WEST SUSSEX COUNTY COUNCIL CONSULTATION

TO:	Arun District Council FAO: Katie Sharp
FROM:	WSCC - Highway Authority
DATE:	8th September 2022
LOCATION:	Land north of Toddington Lane (adjacent to Lyminster Bypass) Hampton Park Littlehampton BN17 7PP
SUBJECT:	LU/417/21/OUT Outline application with some matters reserved (except access) for the erection of up to 71 No dwellings. Further information received in Katie Sharp's email of 26th August 2022.
DATE OF SITE VISIT:	n/a (desktop study)
RECOMMENDATION:	More Information Required
S106 CONTRIBUTION TOTAL:	n/a TBA

This is the second WSCC County Highways (CHA) response to the above outline planning application with some matters reserved (except access) for the erection of up to 71 dwellings. Comments below respond to additional information received from the case officer dated 26th August 2022 and should be read alongside previous CHA response dated 16th February 2022.

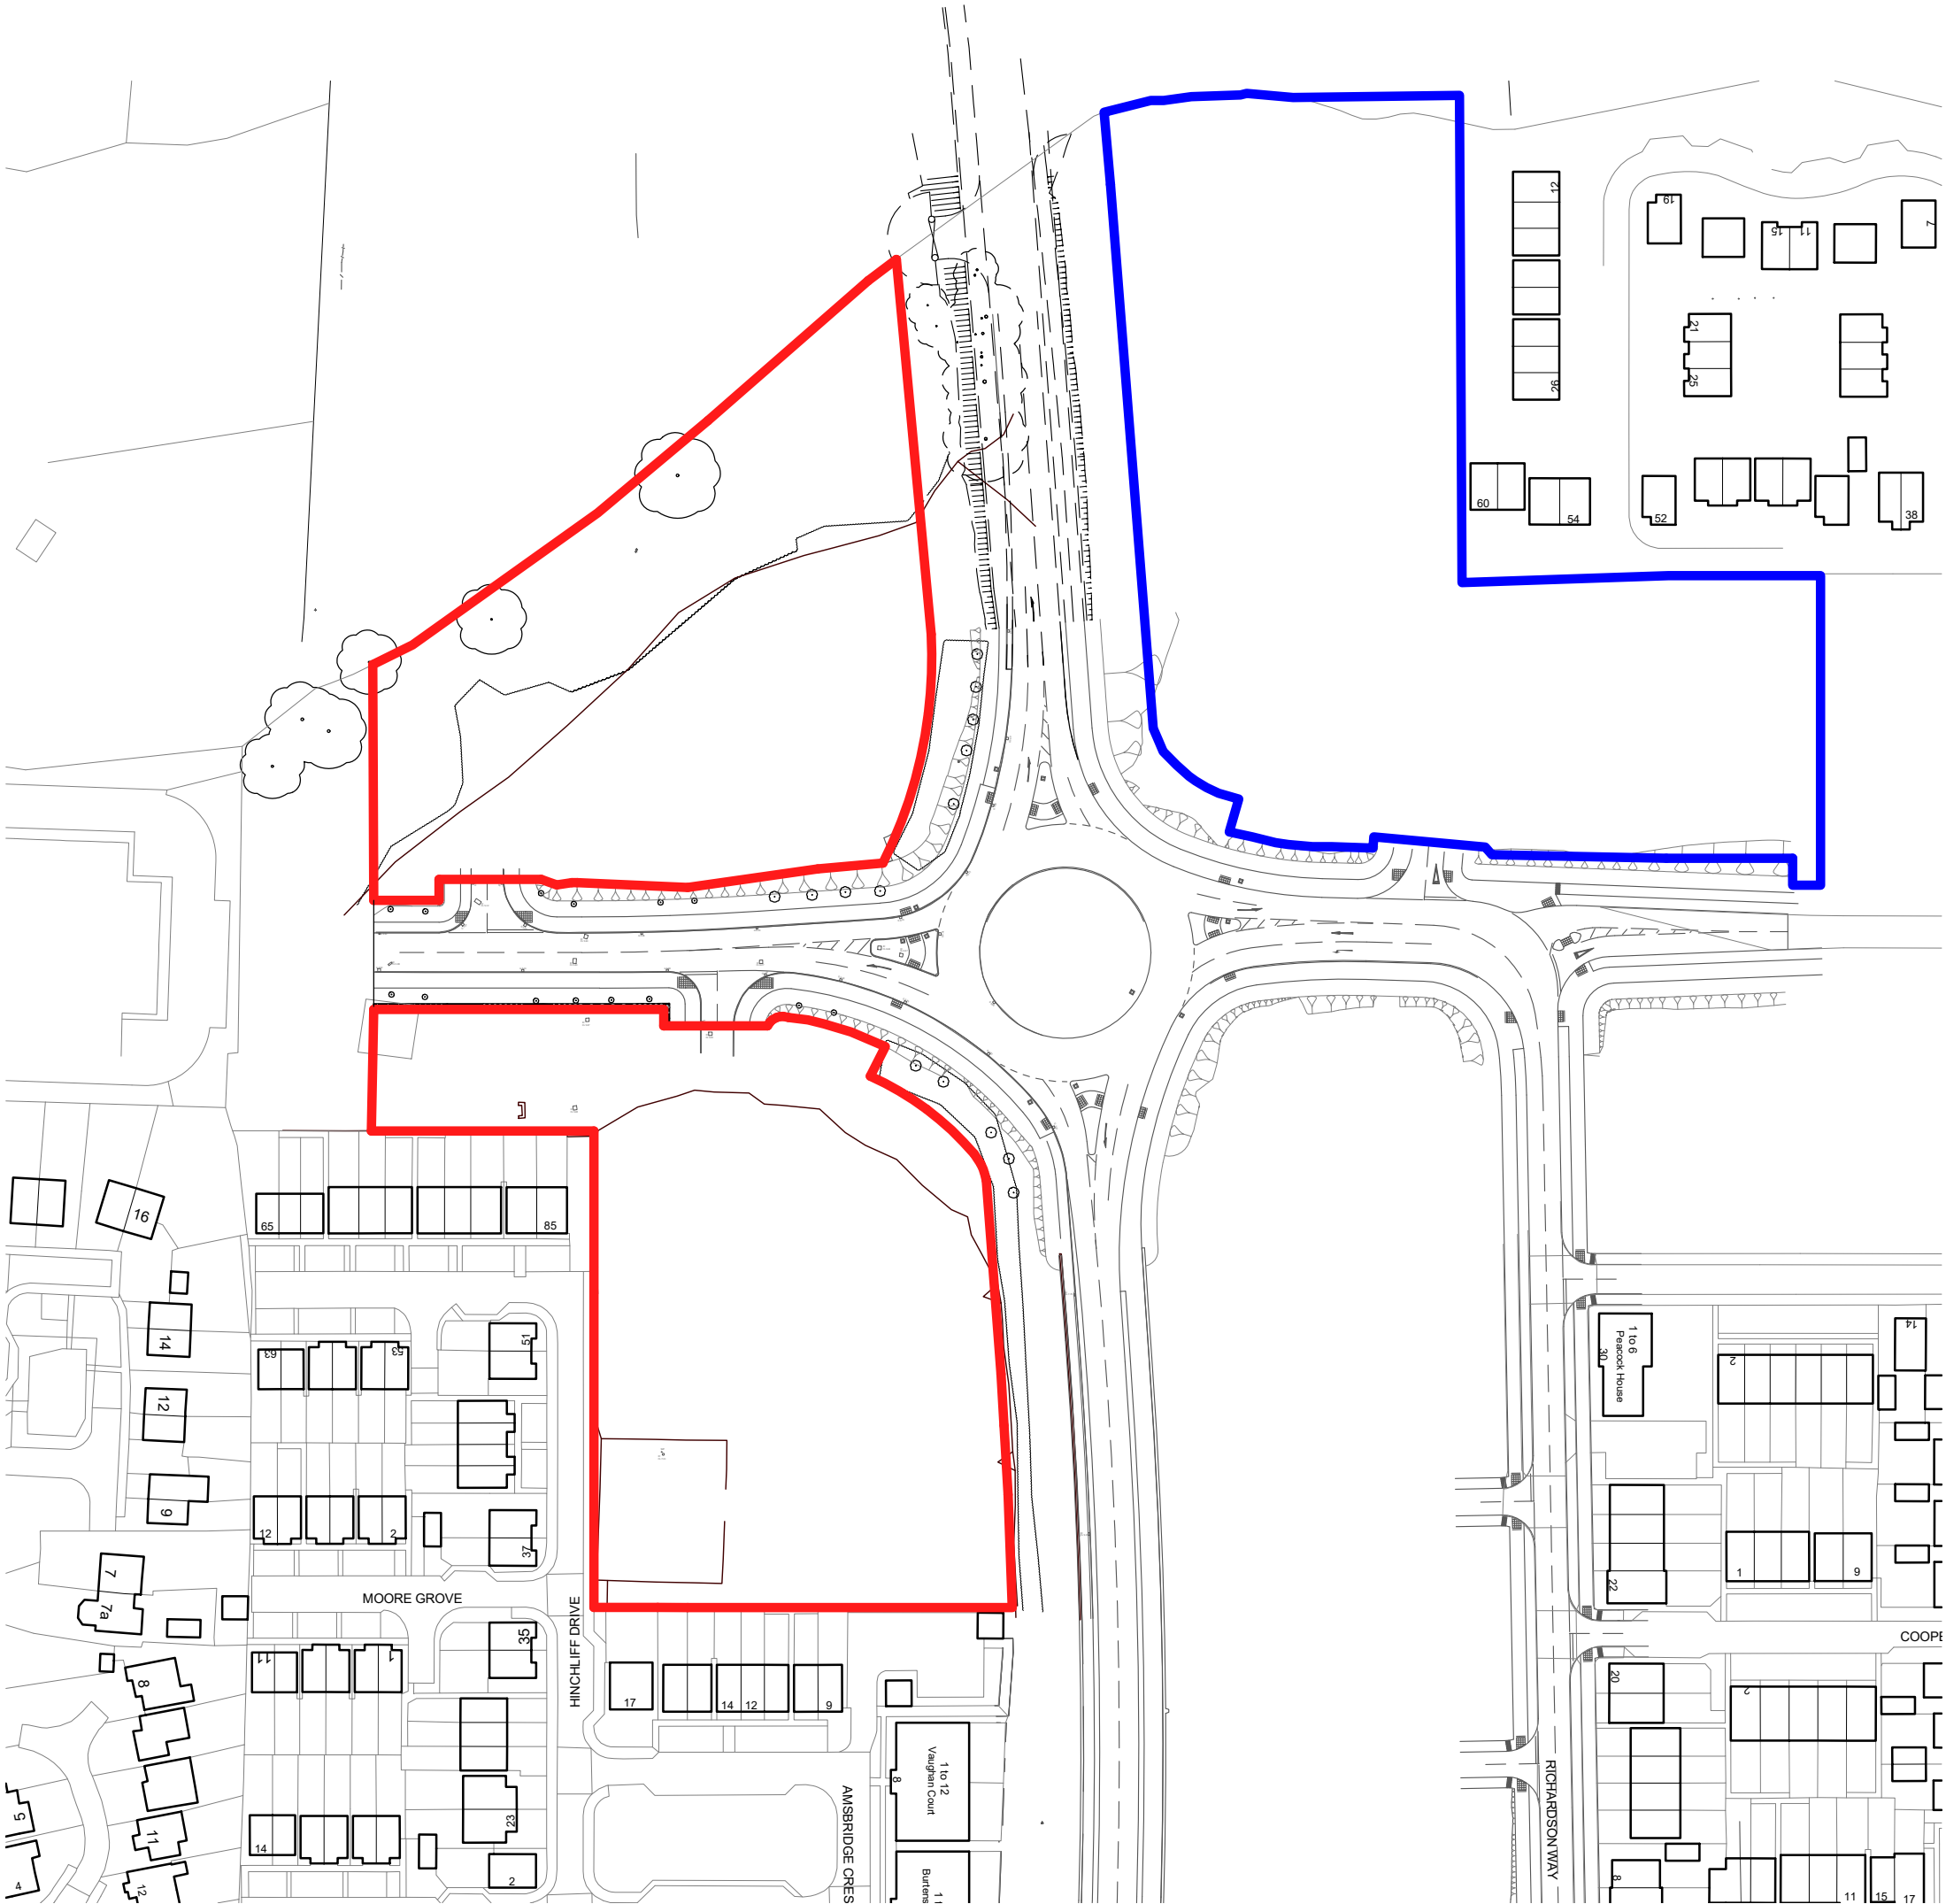
1. Provision of plans showing improved pedestrian and cycle access design at the vehicular access points. *This is now shown on Drawing No. 21023-HNW-ZZ-00-DR-A-2001 Revision P03. However, at the detailed design stage, the road markings delineating the start/finish of the cycle path on the carriageway should either be fully on the public highway **or** fully within the development on the private internal carriageway and not part on one and part on the other. This will require a minor amendment to both access points at the detailed design stage. This is to ensure that future maintenance of the lines will be achieved consistently across both access points.*

2. Provision of a plan showing additional foot and cycle connections to and from the adjacent walking and cycle paths. *This is now shown indicatively on Drawing No. 21023-HNW-ZZ-00-DR-A-2001 Revision P03. However, at the detailed design stage, the road markings delineating the start/finish of the cycle path on the carriageway should either be fully on the public highway **or** fully within the development on the private internal carriageway and not part on one and part on the other. This will require a minor amendment to both access points at the detailed design stage. This is to ensure that future maintenance of the lines will be achieved consistently across both access points. With regard to the paths emerging to the new Southern Relief Road, part of the land in-between the site and road is, to the best of the CHA's knowledge, in the control of Persimmon Homes. Therefore, to achieve these paths would require the permission of the landowner and they would need to be party to any S106 Agreement to secure them. Furthermore, at the detailed design stage, the applicant would need to demonstrate suitable gradients for users.*
